Your Ref: A/36/18/OUT

Our Ref: NW/ARU/18/05A

RE: - Land off Arundel Road, Angmering BNJ16 4ET

Thank you for your correspondence of 28th March 2018, advising me of an Outline planning application with some matters reserved for the erection of up to 200 dwellings with access, public open space, landscaping and sustainable drainage system (SuDS) with vehicular access point from Arundel Road, one full-sized adult football pitch and the demolition of industrial units and one residential dwelling. Departure from the Development Plan for which you seek advice from a crime prevention viewpoint.

Figure 5.7: 'Designing out crime' Principles.

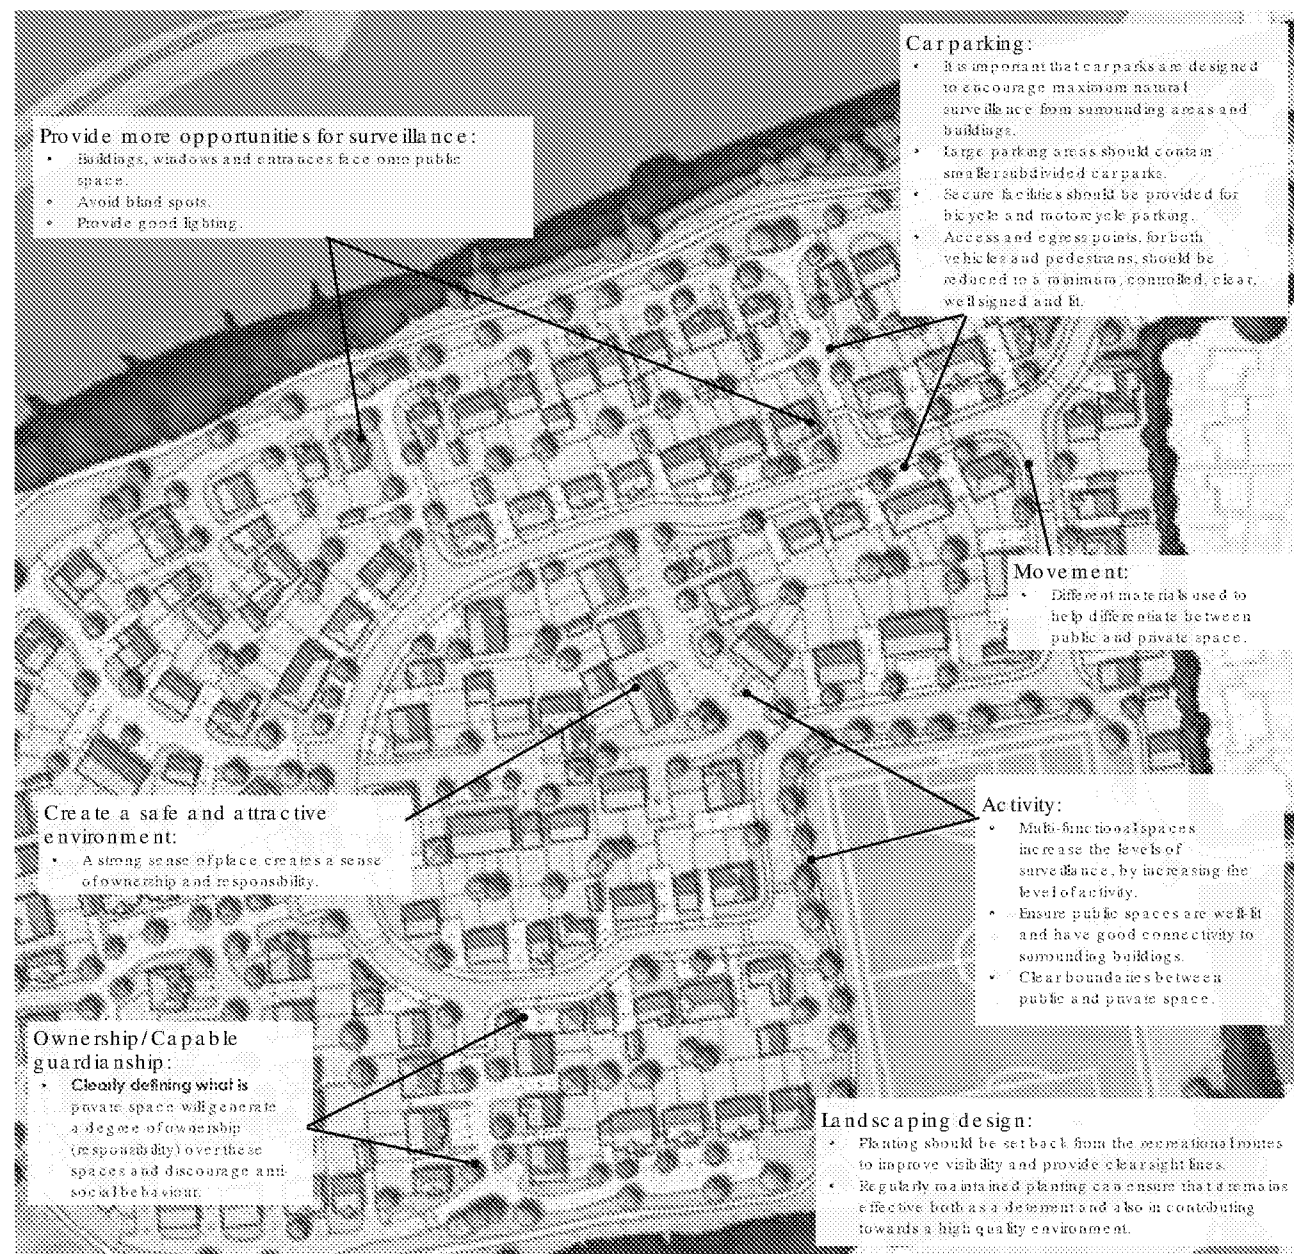
The plan within the Design and Access statement is very difficult to read due to the pixelated view. However, it appears the development in the main has outward facing dwellings with back to back gardens which has created good active frontage with the streets and the public areas being overlooked, this design has all but eliminated the need for vulnerable

rear garden pathways. Parking in the main has been provided with in-curtilage, garage & car barn parking and a number of on street parking bays, this should leave the street layout free and unobstructed.

As the first line of defence, perimeter fencing must be adequate with vulnerable areas such as side and rear gardens needing more robust defensive barriers by using walls or fencing to a minimum height of 1.8metres.

In circumstances that require a more open feature such as a garden overlooking a rear parking court or a rear garden pathway, 1.5metre high close board fencing topped with 300mm of trellis can achieve both security and surveillance requirements. This solution provides surveillance into an otherwise unobserved area and a security height of 1.8 metres. Gates that provide access to the side of the dwelling or rear access to the gardens must be robustly constructed of timber, be the same height as the adjoining fence and be lockable from both sides. Such gates must be located on or as near to the front of the building line as possible.

Where communal parking occurs it is important that they must be within view of an active room within the property. An active room is where there is direct and visual connection between the room and the street or the car parking area. Such visual connections can be expected from rooms such as kitchens and living rooms, but not from bedrooms and bathrooms. Gable ended windows can assist in providing observation over an otherwise unobserved area.

Any potential areas of play should be situated in an environment that is stimulating and safe for all children, be overlooked with good natural surveillance to ensure the safety of users and the protection of equipment, which can be vulnerable to misuse. I would recommend that the eventual location is surrounded with railings with self-closing gates to provide a dog free environment.

Provision should be made to prevent the access of vehicles and motor cycles using the perimeter pedestrian recreational route.

There may be a potential desire line for residents in the north and west of the development to cut off the South East corner of the site if they are heading towards the village centre by cutting through the sports club.

Lighting throughout the development will be an important consideration and should conform to the recommendations within BS5489:2013.
